WEST SUSSEX COUNTY COUNCIL CONSULTATION

TO:	Arun District Council FAO:David Spring
FROM:	WSCC - Highways Authority
DATE:	20 March 2020
LOCATION:	Land west of Barton House Manor Park Pagham
SUBJECT:	P/18/20/PL Change of use from highway land to residential use for the development of 4 No. 3 bed terraced houses with associated parking & access. This application affects the setting of a listed building.
DATE OF SITE VISIT:	n/a
RECOMMENDATION:	Advice
S106 CONTRIBUTION TOTAL:	n/a

Site Plan

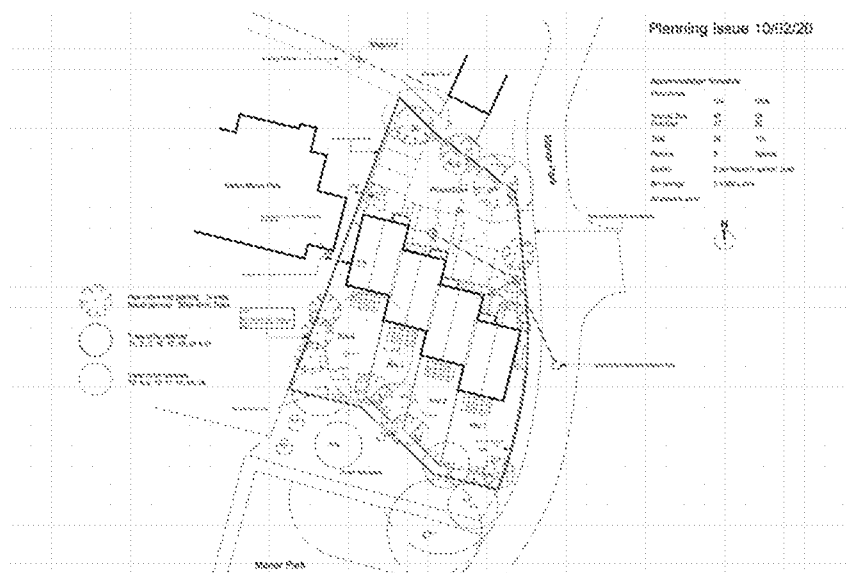
The site plans demonstrated that the access will be served with a 2.4 x 30m visibility splay to the north and a 2.4 x 25m visibility play to the south. This equates to stopping sight distance approach speeds of 23mph and 20mph respectively using the Manual for Streets stopping sight distance calculation coefficient.

It should be noted that the visibility to the north in reality extends beyond the 30m demonstrated.

The applicant has not provided 85th percentile wet weather speed survey evidence to support the above quoted visibility splays. The LHA is minded to accept the splays are adequate for the anticipated road speeds when taking the context of Manor Park into consideration.

No obstruction within these splays shall be greater than 0.6 metres in height. These splays should be secured via condition in perpetuity in the interests of highway safety.

The parking area will provide a total of eight parking spaces to serve the development. All spaces demonstrated are appropriately sized at 2.4 x 4.8 metres.

The parking layout is such that vehicles will be provided the opportunity to turn on site and thus be able to enter and leave the site in the forward gear.

No part of the development shall be first occupied until such time as the vehicular access serving the development has been constructed in accordance with the details shown on the drawing titled Site Plan and numbered IBA/529/02.

No part of the development shall be first occupied until visibility splays of 2.4 metres by 30 metres north and 2.4 x 25 metres south have been provided at the proposed site vehicular access onto Manor Park in accordance with the approved planning drawings.
